April 14, 2015

Project Name: Century Tire Plaza  
Address: 195 Kennebec Street, Portland, ME  
Project ID: 2015-027  
CBL: 34-C-9  
Applicant: Northland Enterprises, LLC  
Planner: Nell Donaldson

On April 14, 2015, the Planning Authority approved with conditions a Level II site plan for the redevelopment of the Century Tire site at 195 Kennebec Street. The decision is based upon the application as submitted by Northland Enterprises, LLC and prepared by FST, Inc., with plan revisions dated April 1, 2015. The proposal was reviewed for conformance with the standards of the City of Portland's site plan ordinance, Article V of the land use code. It should be noted that the plans for the project's Marginal Way and Kennebec Street frontages were found to meet the guidelines of the Marginal Way Master Plan and the Somerset Street Extension Feasibility Study respectively, and that the provision of the sidewalk along the property's eastern boundary was found to meet the city's B-7 and site plan standards related to street connectivity and safe access for all site users. The Level II site plan is approved with the following waivers and conditions:

PROJECT <b>CENTURY TIRE PLAZA</b> 195 KENNEBEC STREET, PORTLAND, ME	
SHEET TITLE <b>DETAILS</b>		CLIENT <b>NORTHLAND ENTERPRISES, LLC</b>	DRAWN: KCS DESIGNED: ADJ CHECKED: ADJ FILE NAME: SP-M160 DETAILS
REVISIONS		DATE DESCRIPTION	DATE: 11.25.14 SCALE: NTS JOB NO.: SP-M160 SHEET: C-7.1

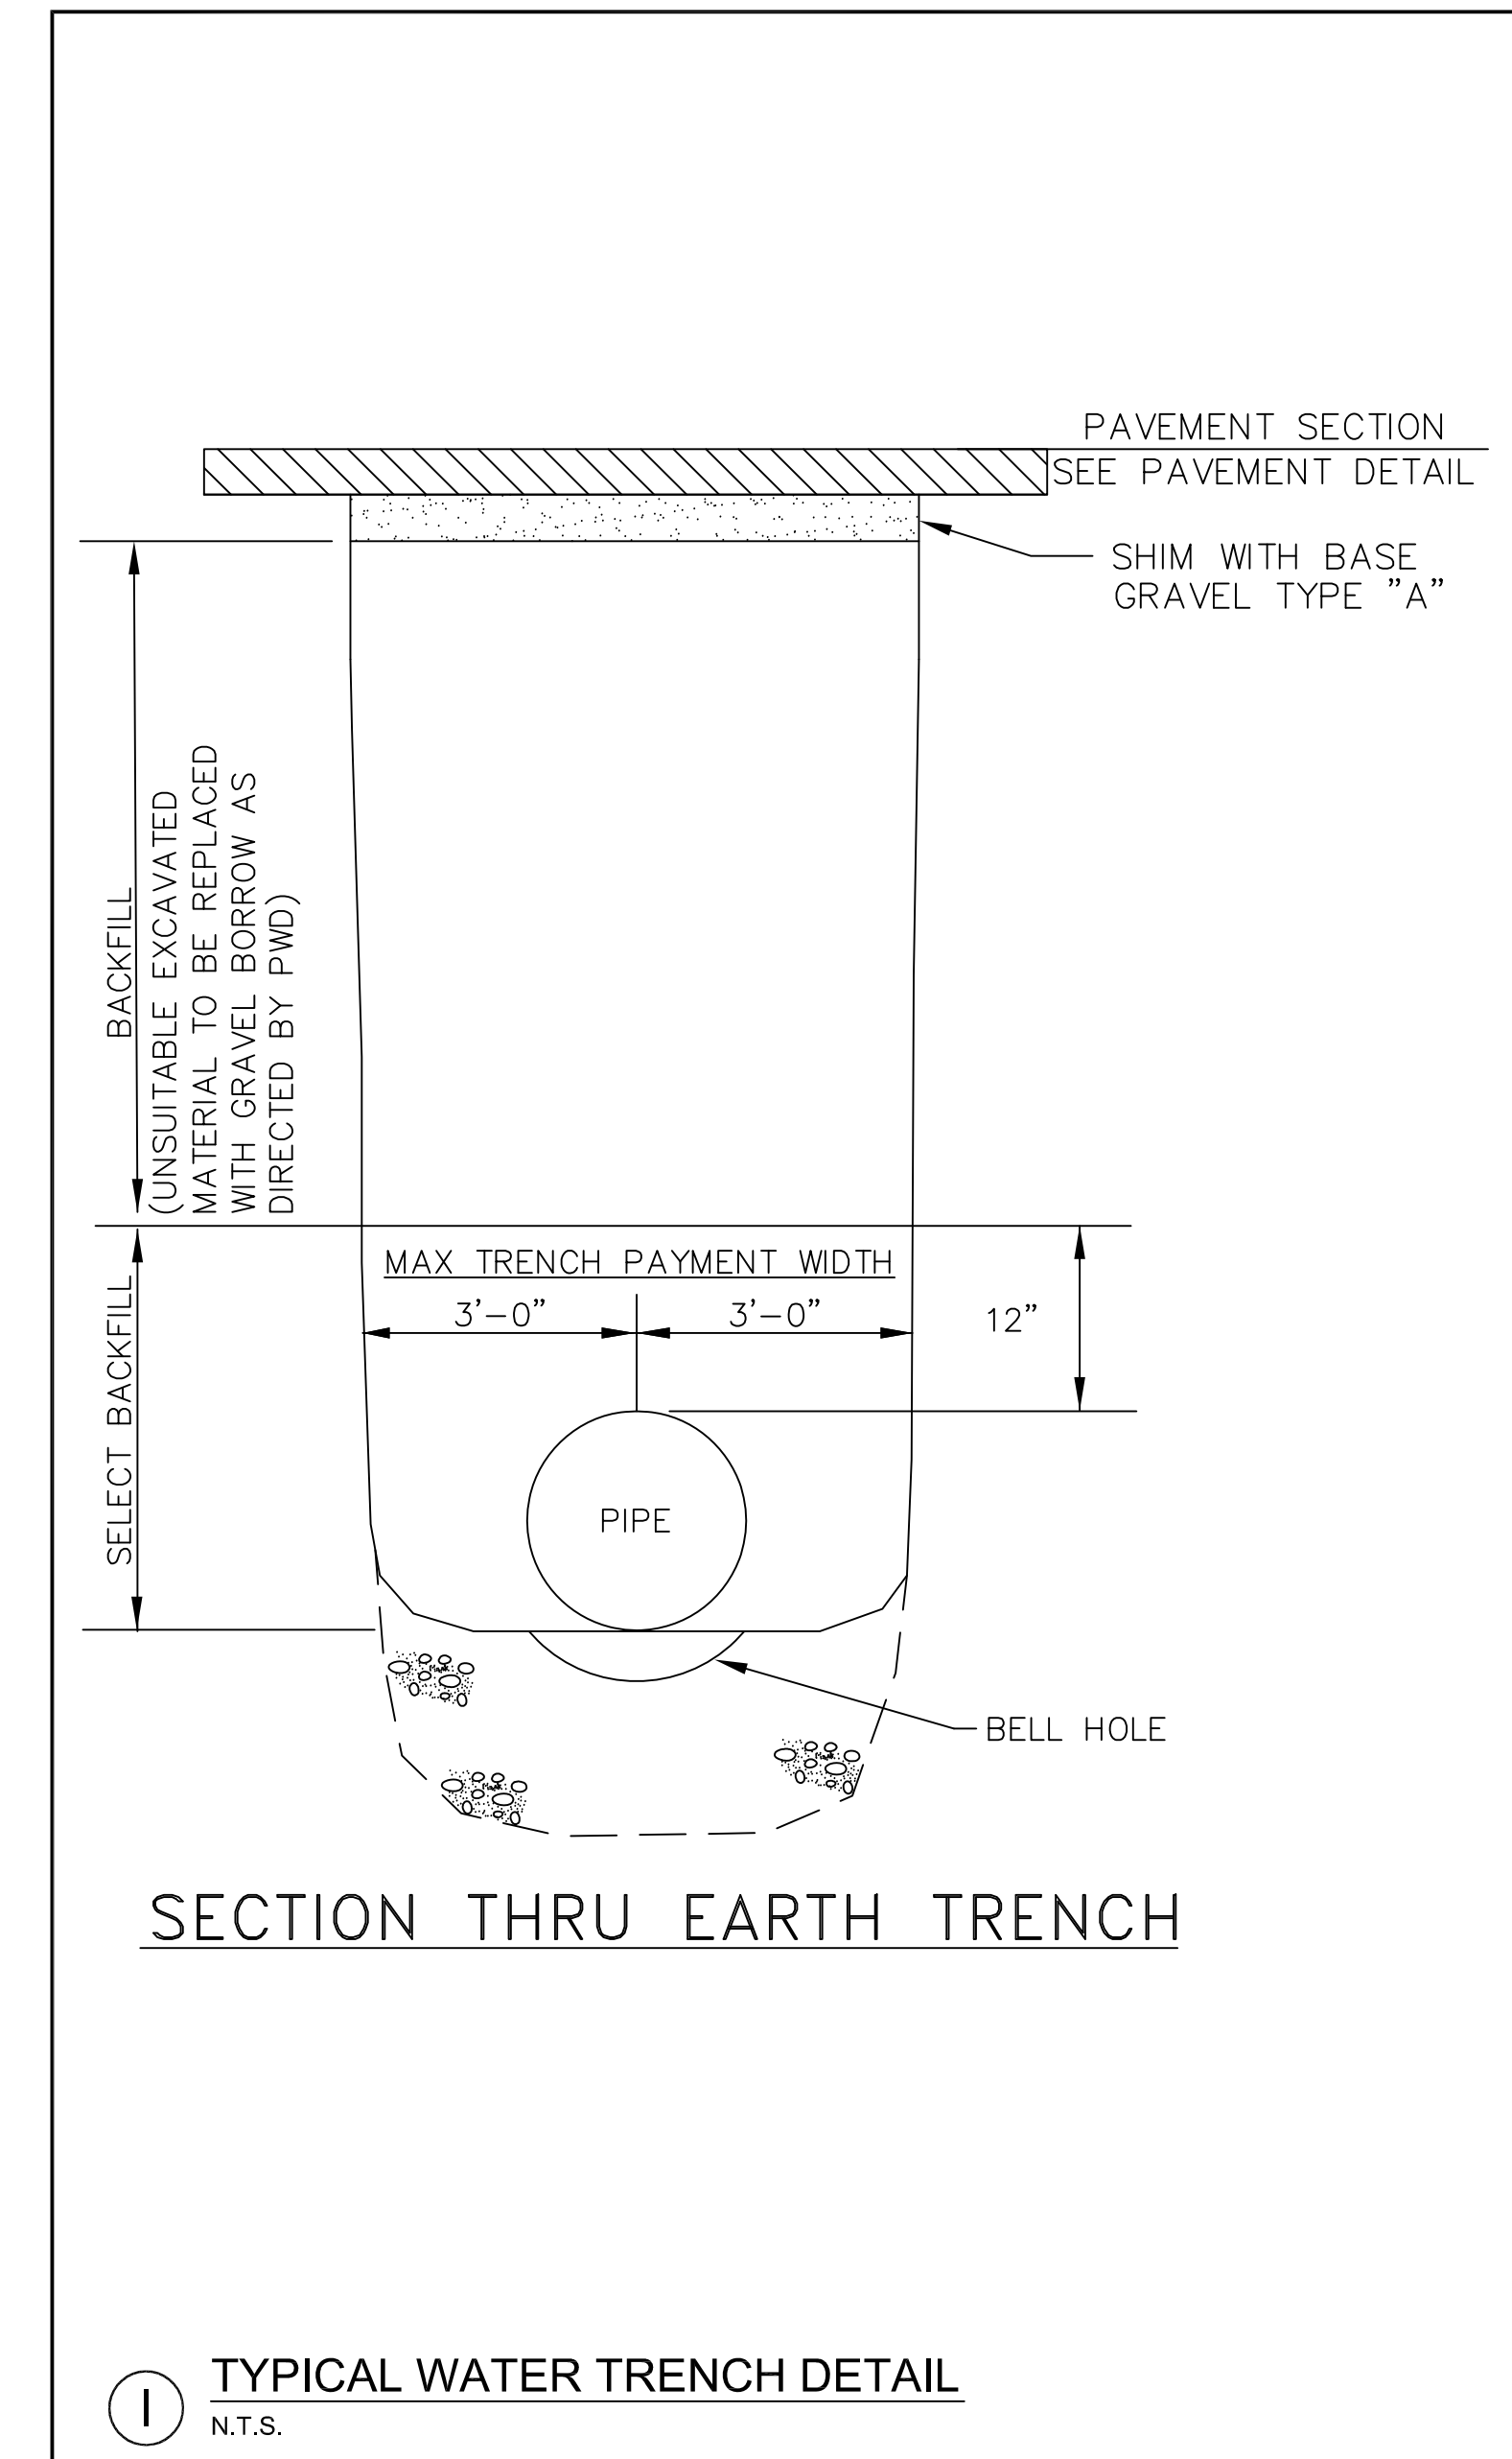
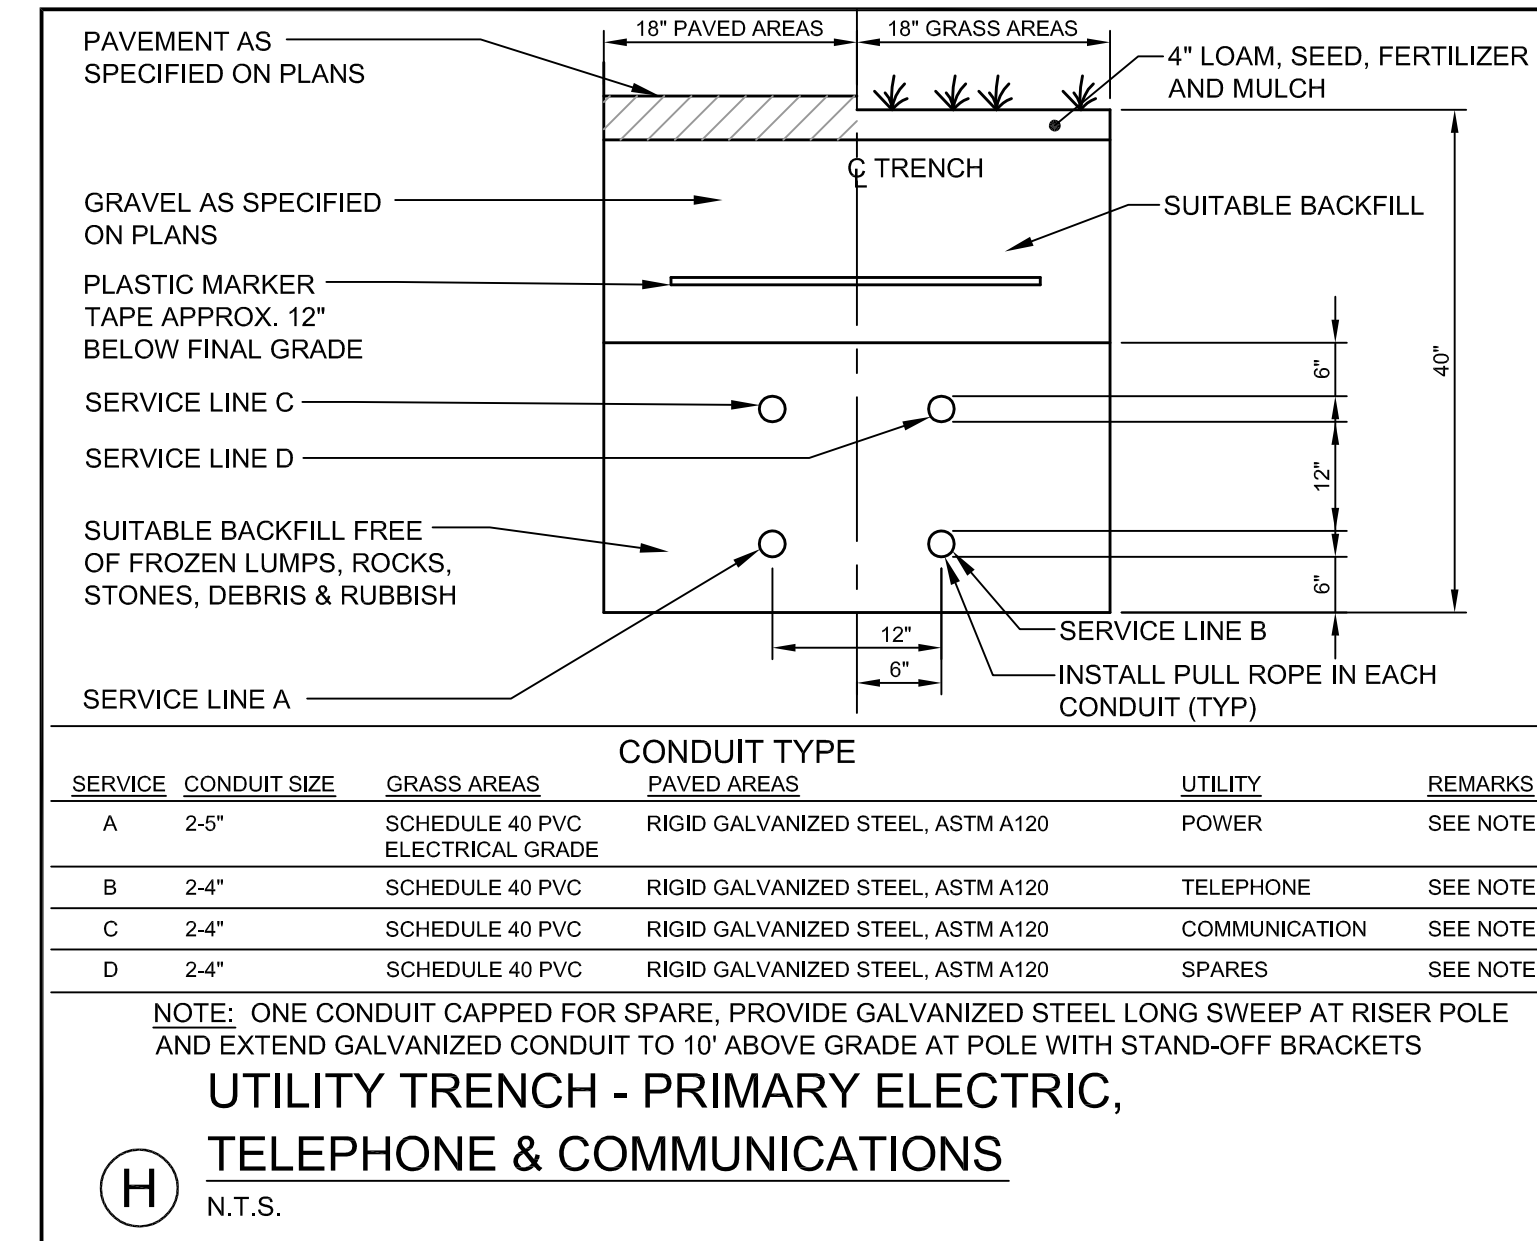
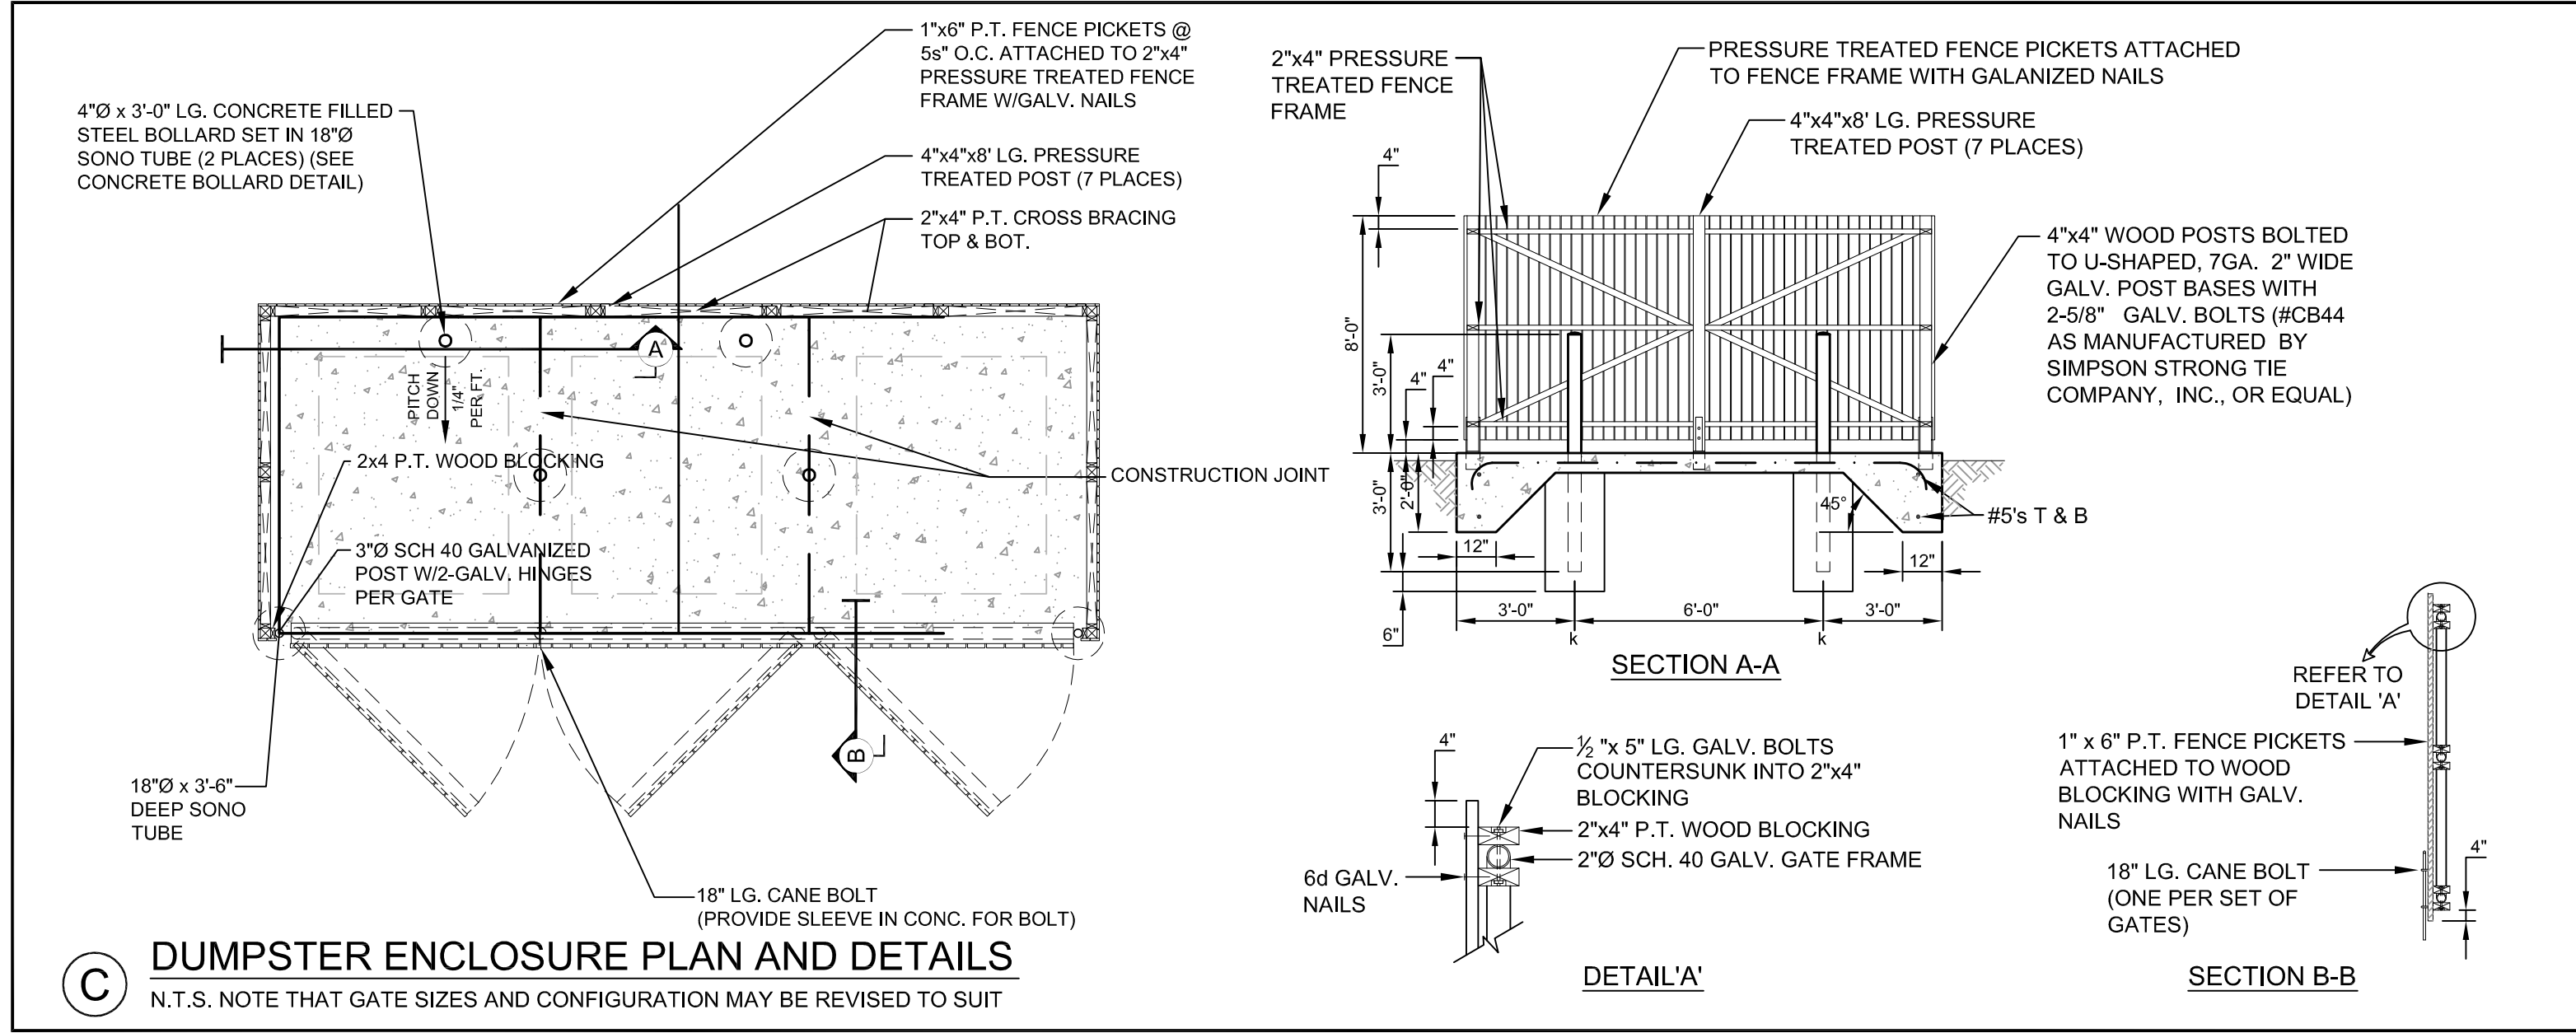
Detail A on plan sheet C-7.1 shows a curb reveal of 6 inches along Kennebec Street. The City standard for curb reveal is typically 7 inches. The curb reveal should be changed to match the City standard unless there are over-riding considerations that require a 6 inch curb reveal. A change to 6 inch curb reveal may require changing the specification for granite curb terminal pieces from 6 feet to 7 feet in length.

6. The applicant shall revise details to depict the city's standards for curb reveal and depth of base gravel for a brick sidewalk on bituminous base for review and approval by the Department of Public Services;
